**Re: PA22-024- Marysville 44th PRD – Technical Review 1
7315 / 7417 44th St NE – APN(s) 30053500303700 / 30053500303600**

This letter is provided as response to comments dated August 17, 2022. Each item has been carefully reviewed and considered and the following is a summary of how each item was addressed.

CONCEPTUAL SEWER PLAN
 7315 & 7417 - 44TH ST NE
 MARYSVILLE, WA
 PARCELS 3005350030-3600-3700

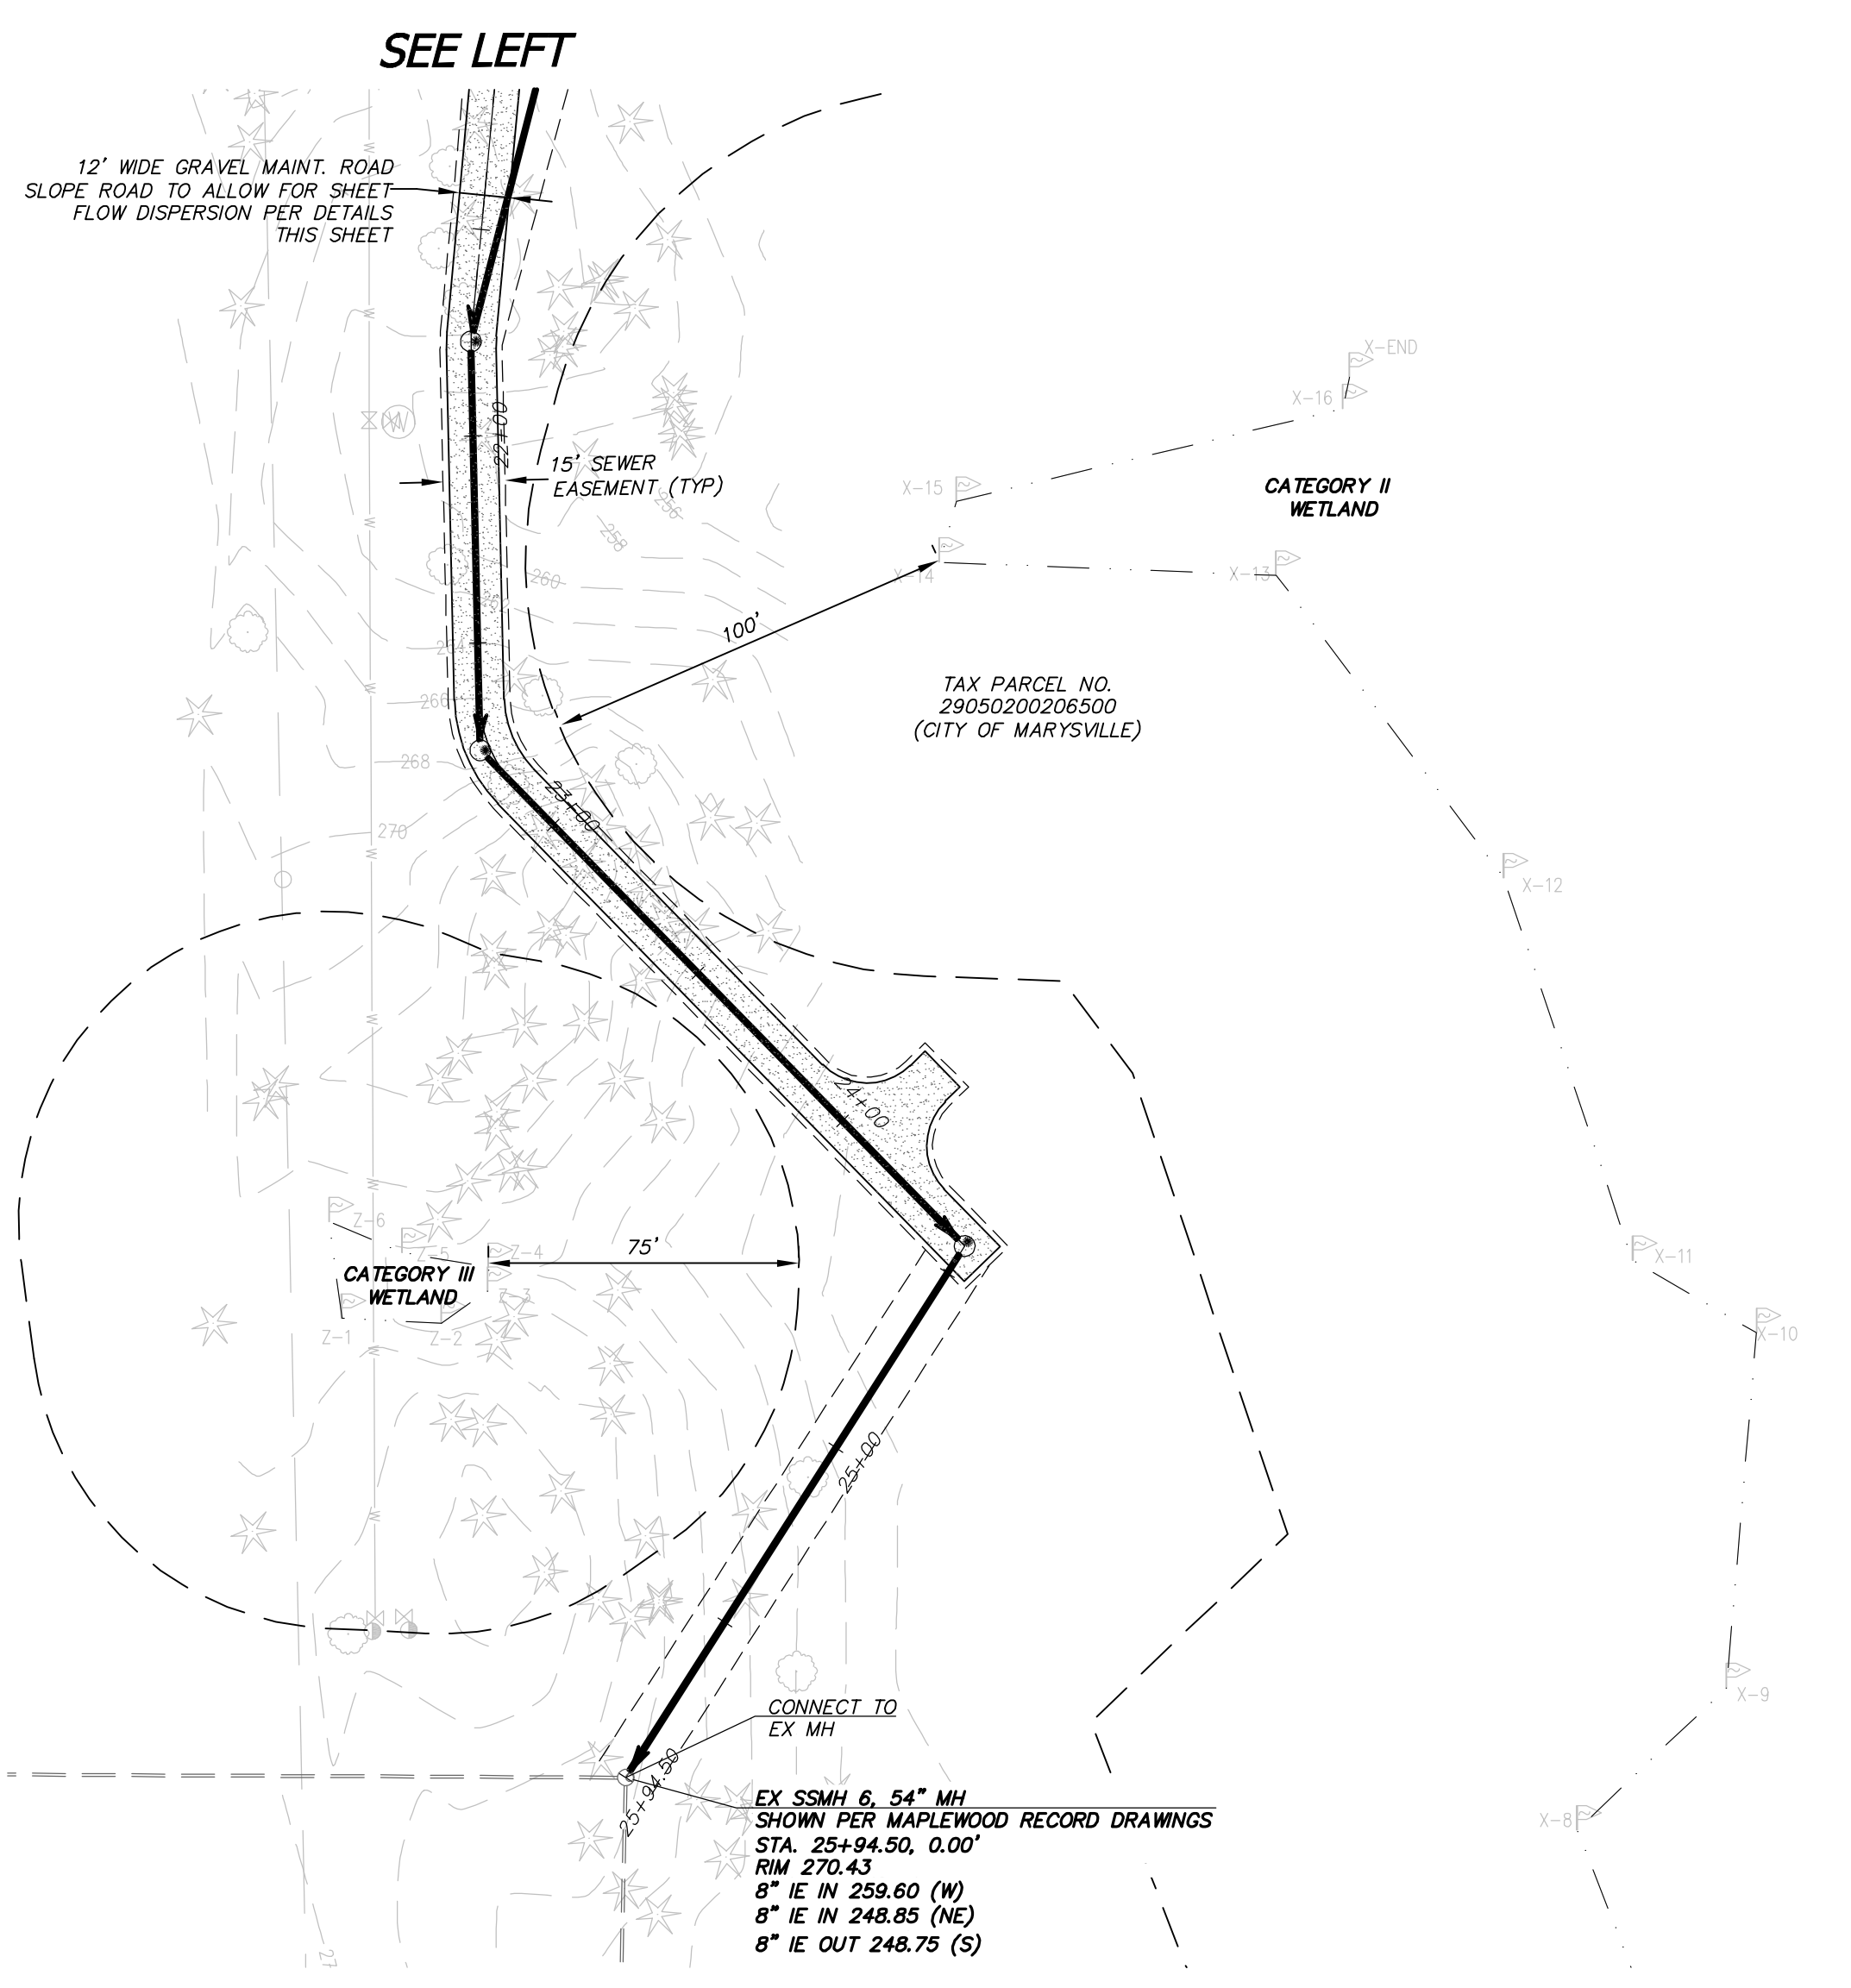
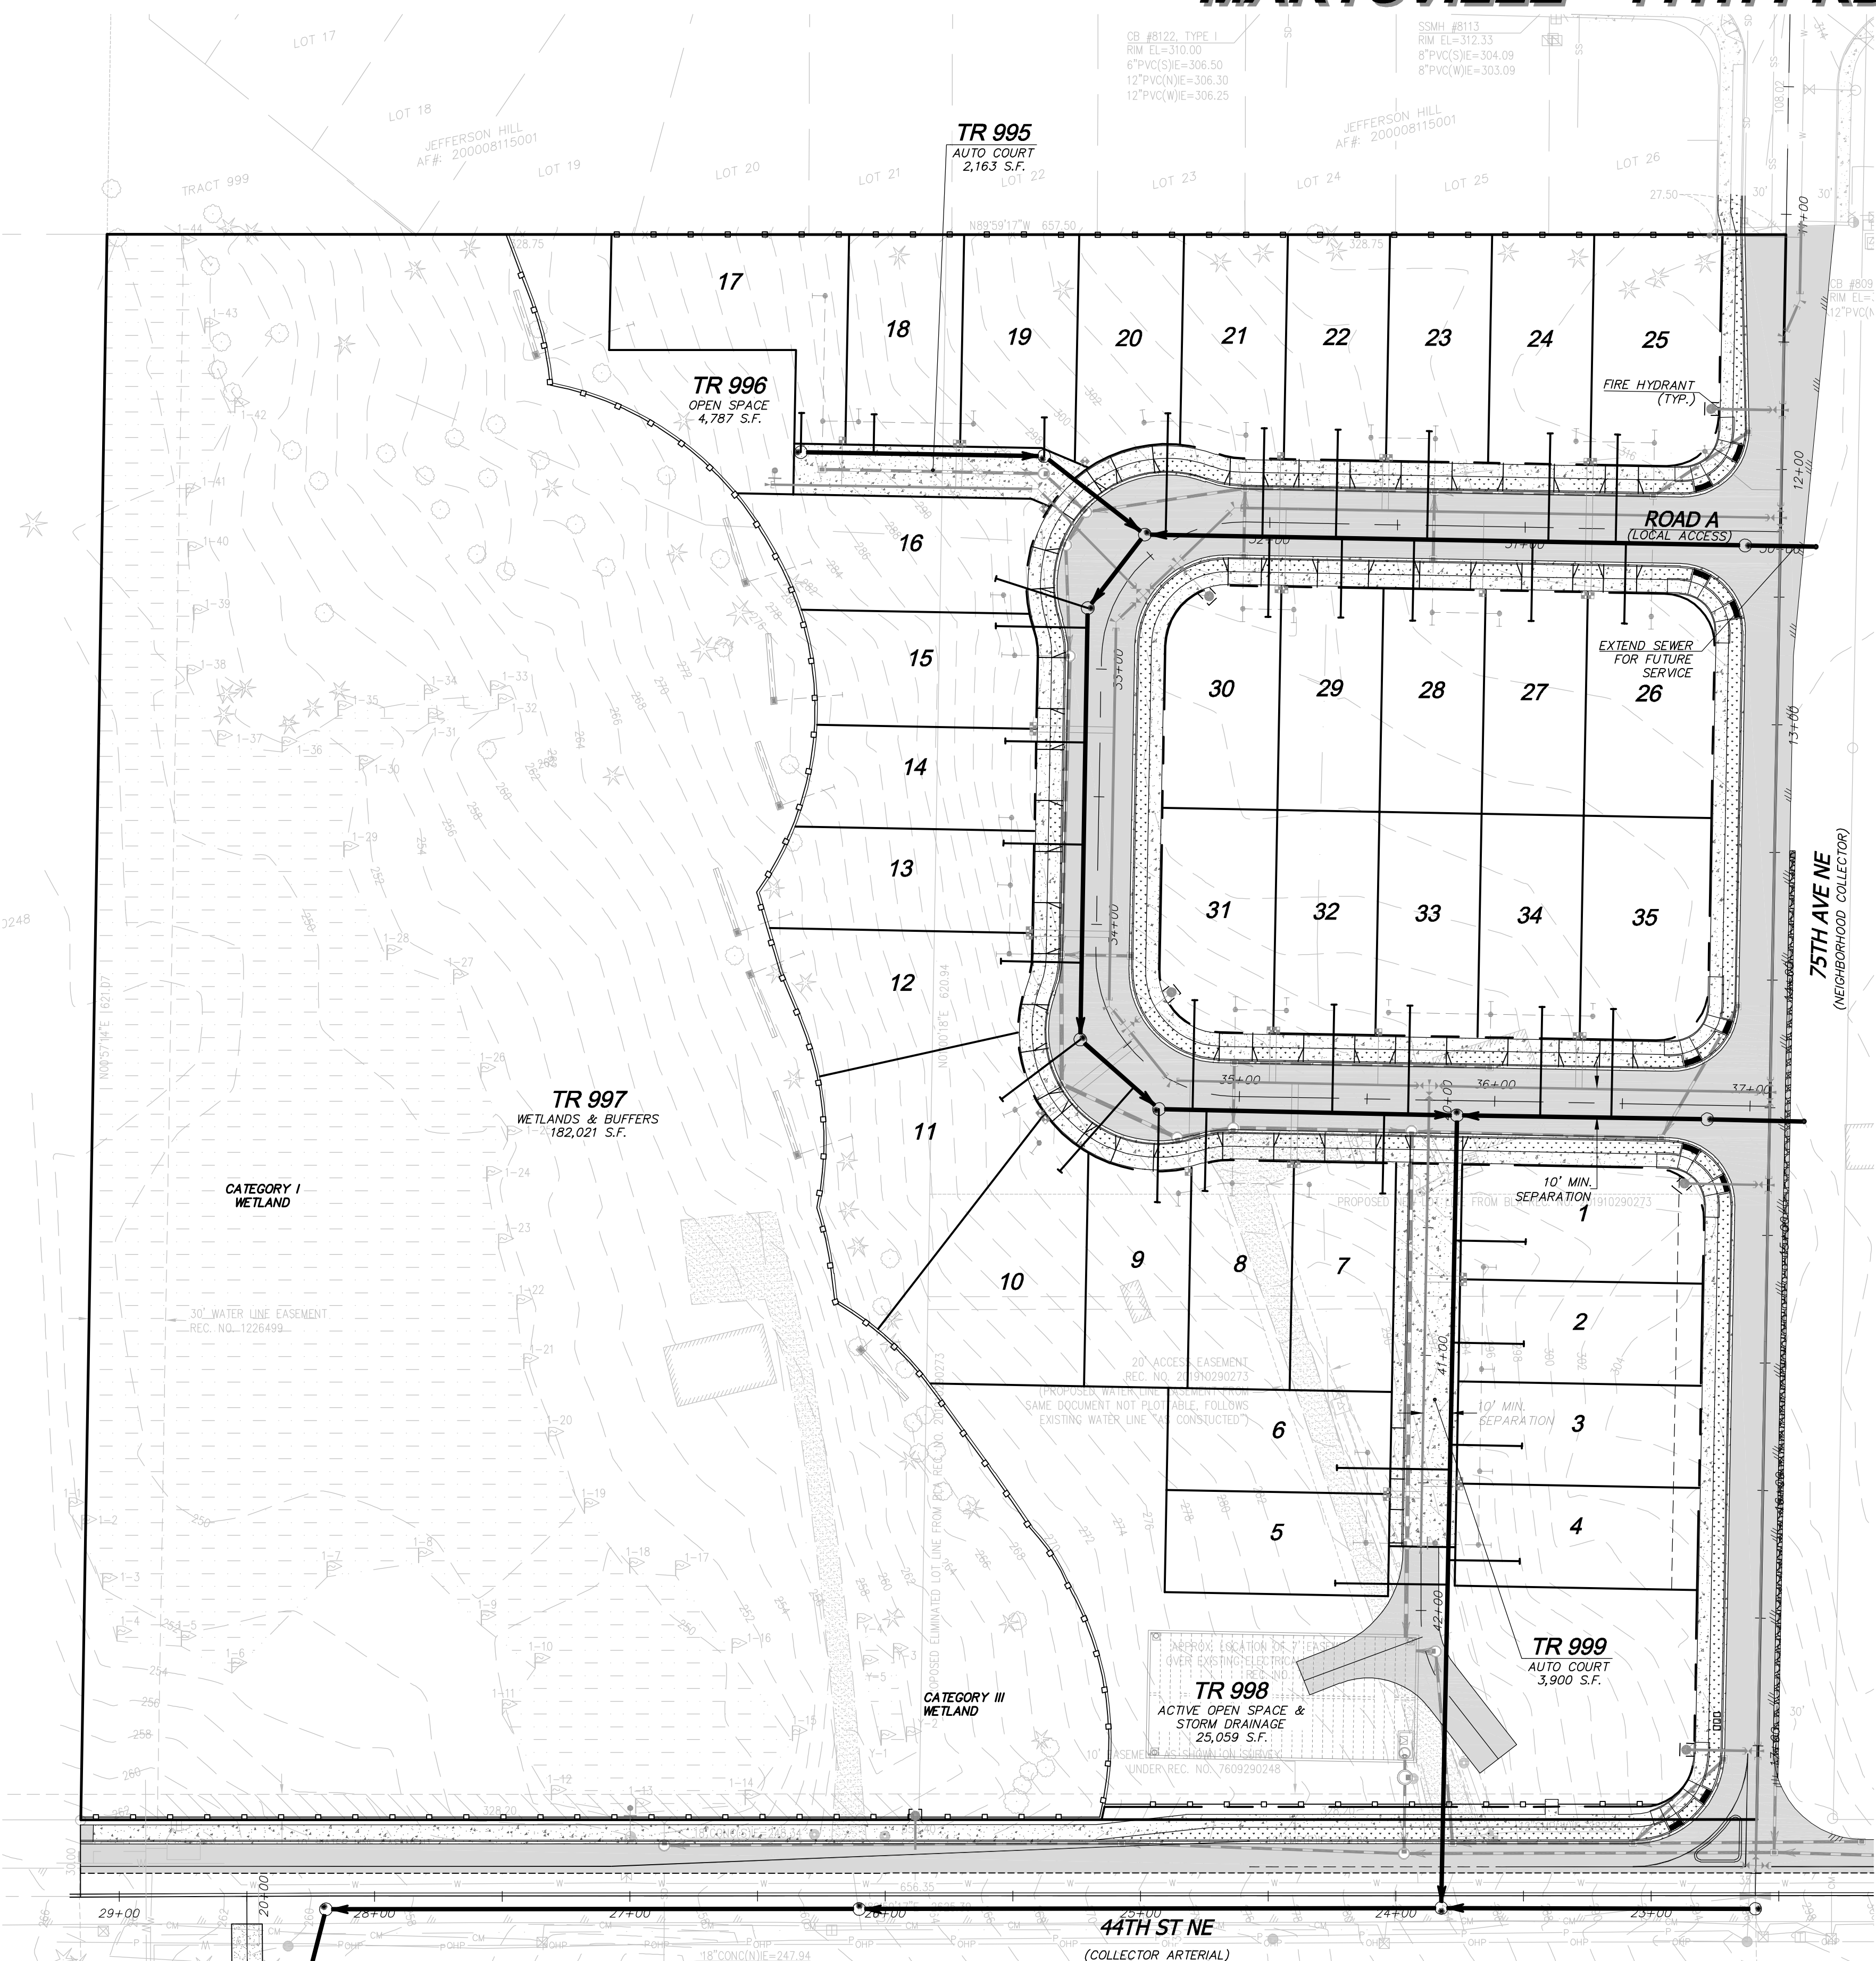
- a. Sewer will need to be installed along the projects frontage. *This includes along 75th Ave NE to the north at least to service parcel number 00590700018101.*

Per meeting with staff, the sewer in Road A will be extended 50 feet east to 75th to address service to said parcel.
